SUBJECT: Engineering Review Comment
Mountain View Electric Association Inc. (MVEA)

Project Name: Copper Chase at Sterling Ranch – Final Plat

Project Number: SF2316

Description: A proposed development of 138 residential lots and 10 tracts on approximately 20 acres located southeast of Vollmer Rd. and the future Marksheffel Rd. in Township 13S, Range 65W, Section 05.

FINAL PLAT  
COPPER CHASE AT STERLING RANCH  
FILING NO. 1  
JOB NO. 09-014  
DATE PREPARED: 04/27/2023  
DATE REVISED: 07/14/2023

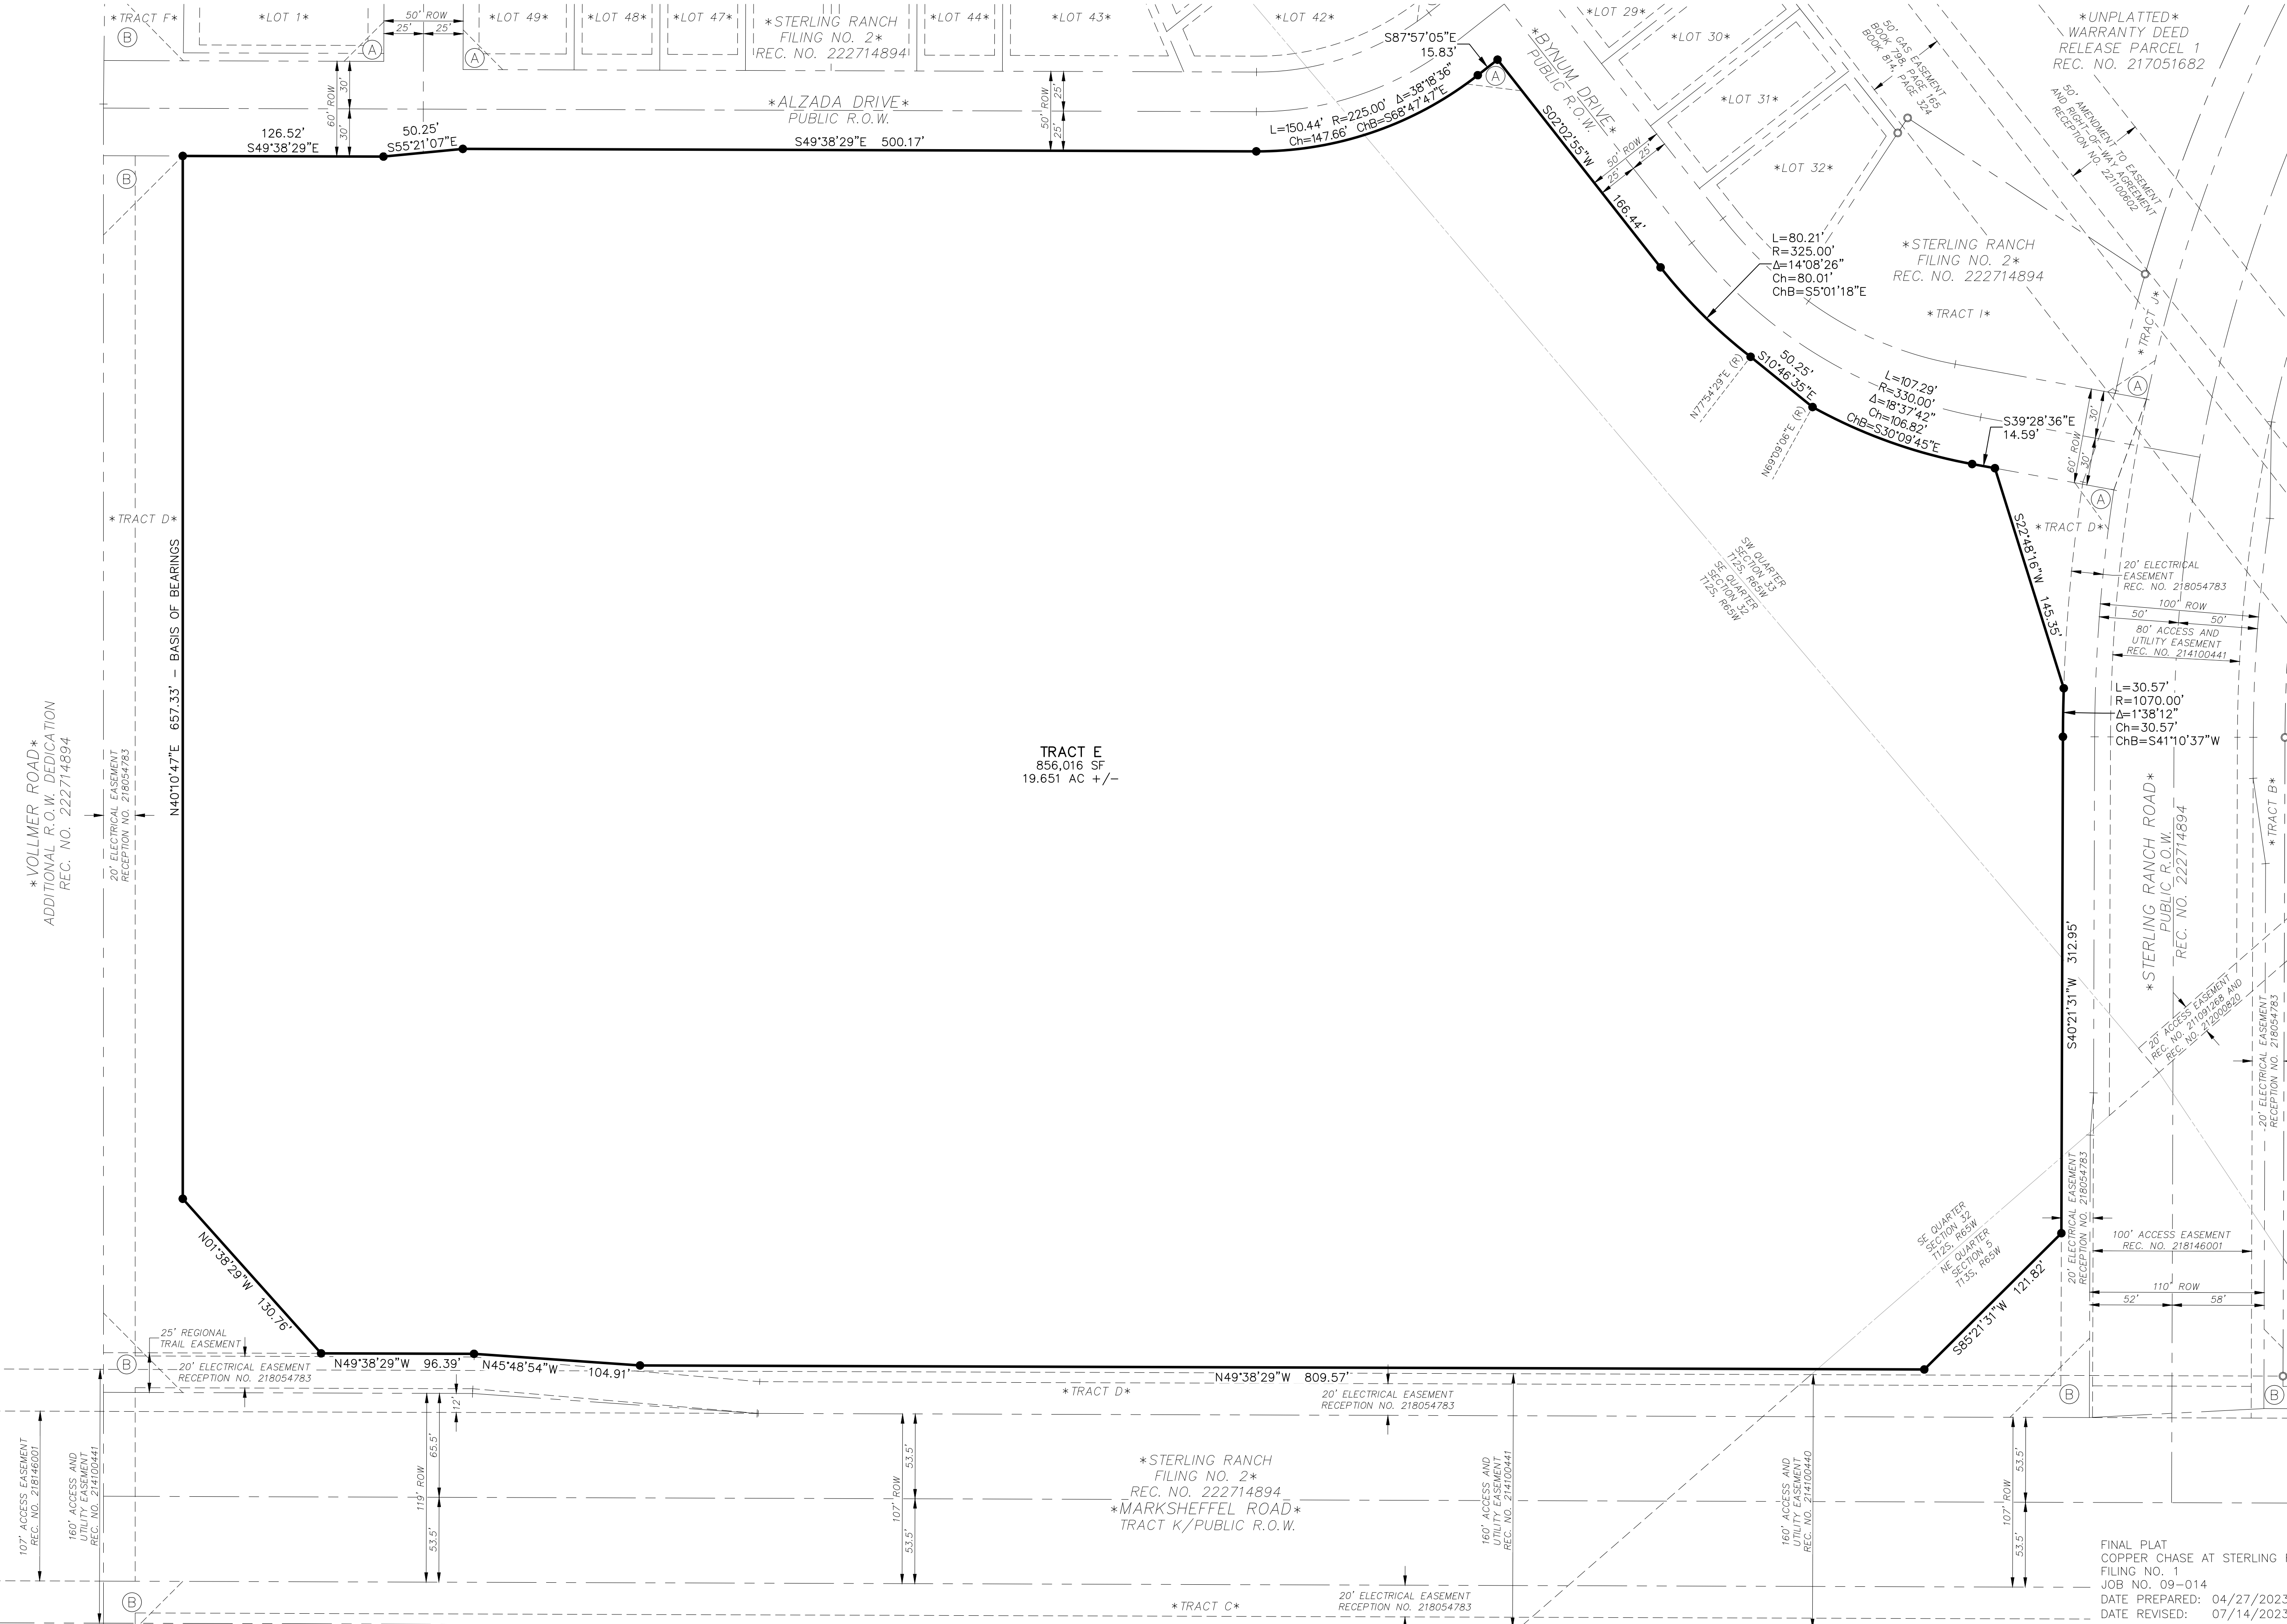
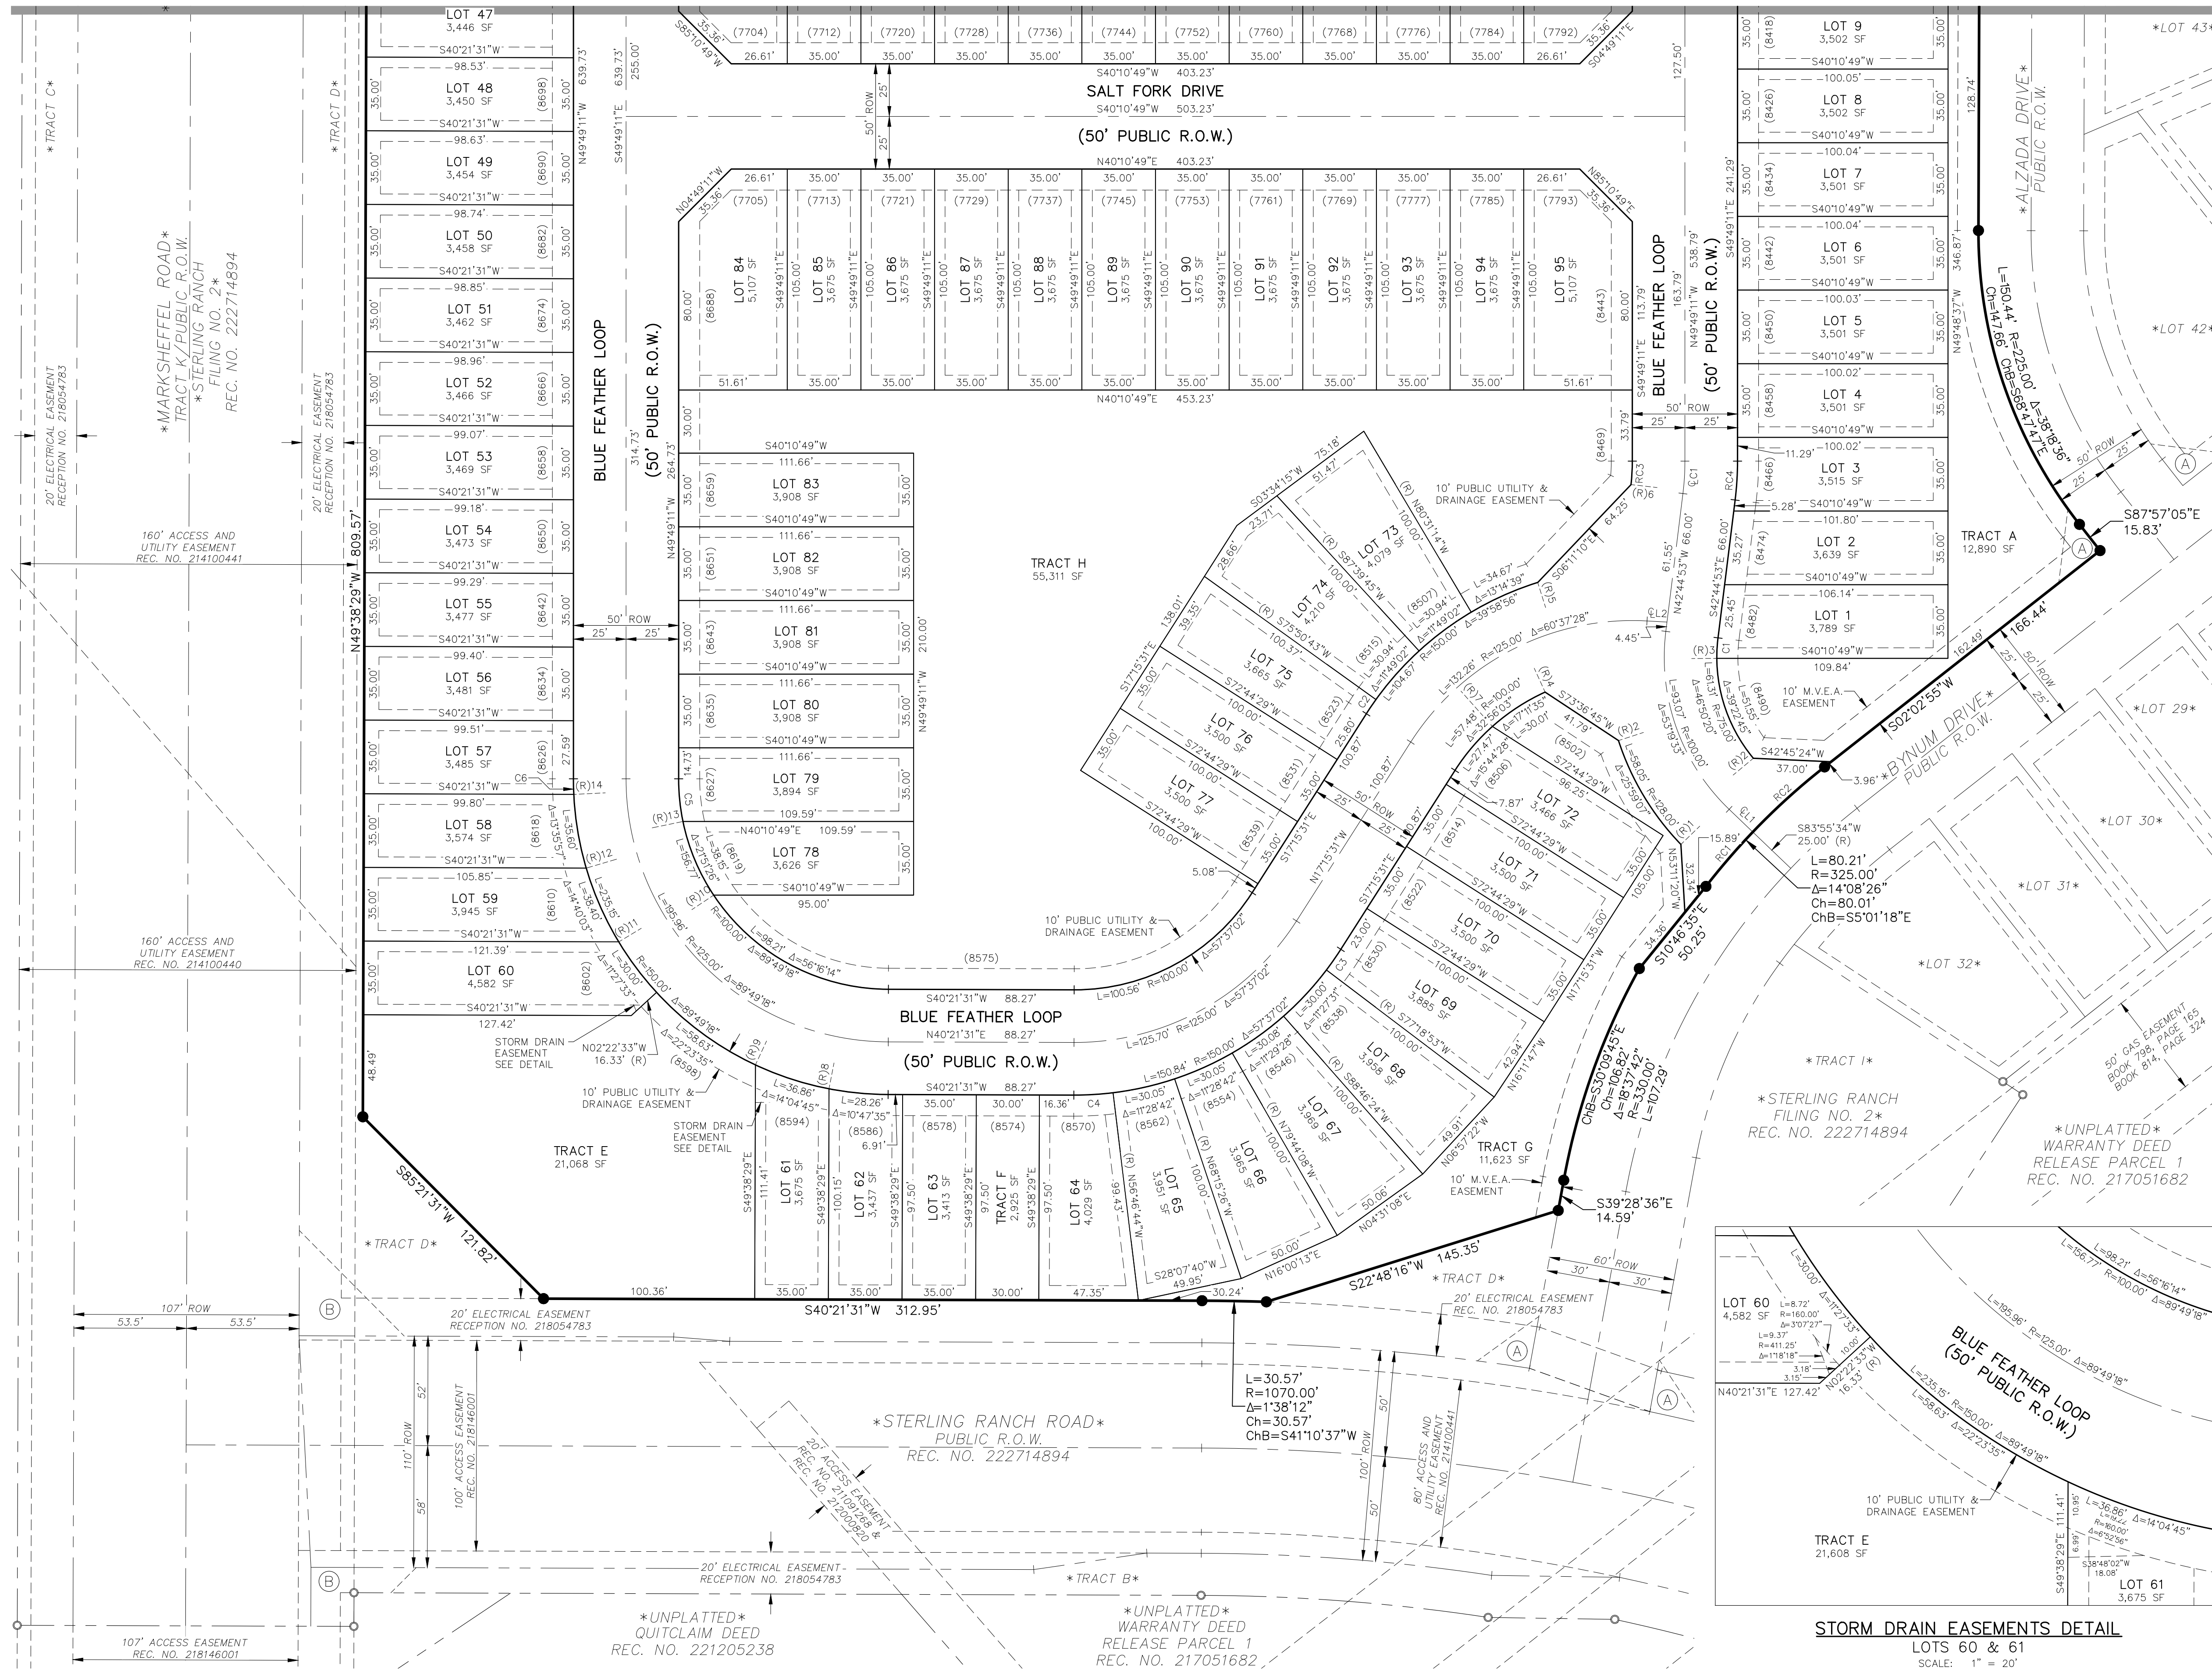
If no public improvement easement, MVEA requests the front lot line easement to be a ten (10) foot public utility easement instead of a five (5) foot public utility easement with a ten (10) foot private easement. MVEA also requests the platting of MVEA's existing facilities with easements on the plat. Additional easements may be required.
